OFFICER DELEGATED REPORT

Reference No.: 23/03119 **Cert of Lawfulness of Proposed Dev**
Proposal: Certificate of lawfulness to determine whether the proposed 1 no. front porch extension, 1 no. side porch extension, 1 no. single storey side extension, 1 no. single storey side/rear extension and 1 no. single storey rear extension is lawful.
Location: Bath Cottage Bath Road Littlewick Green Maidenhead SL6 3QR
Applicant: Mr And Mrs Werakso
Agent: Mrs Bronwen Gombert
Date Received: 15 December 2023
Case Officer: Ritu Singh
Recommendation: Refuse
Parish/Ward: White Waltham Parish Hurley And Walthams

SCALE 1:50@A1 / 1:100@A3 A1 SHEET
STATUS
PRELIMINARY
DRAWING NO
0173-GA-0007
REV
P02
© 2023 Connected Architecture Limited. All rights reserved

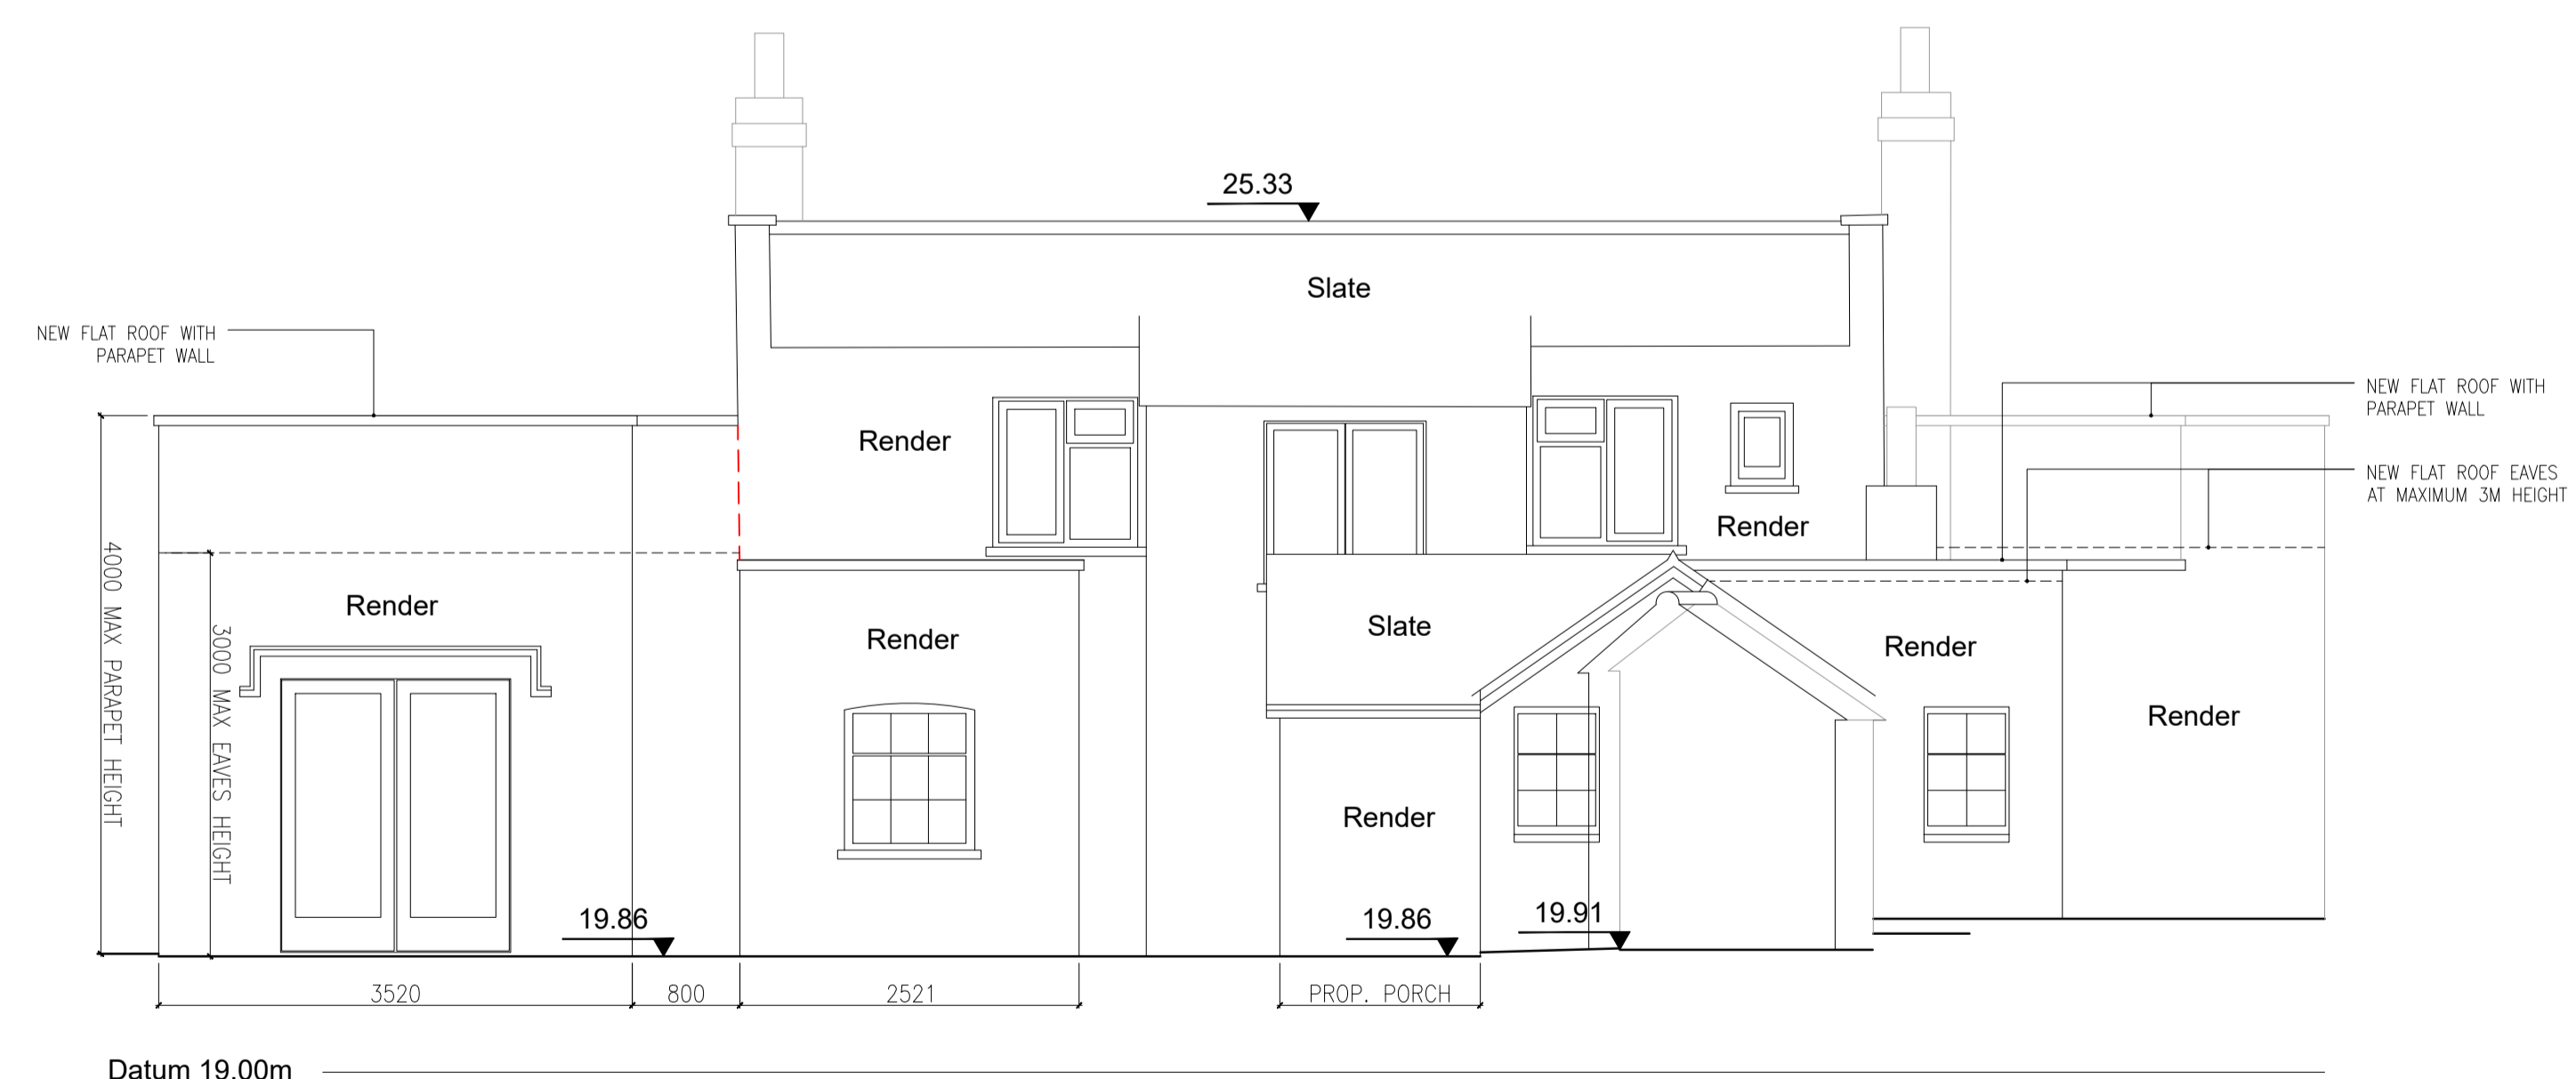
The enlarged part (west elevation) of the dwellinghouse (where stepped height has been proposed) would be within 2 metres of the boundary of the curtilage of the dwellinghouse and the height of the eaves of the enlarged part would exceed 3 metres. **The proposal DOES NOT comply.**

The proposal is not automatically granted planning permission under Article 3 and Schedule 2, Part 1, Class A of the Town and Country Planning (General Permitted Development) Order 2015 (as amended), as proposal fails to comply with condition A.1(i) hence an express grant of planning permission is required.
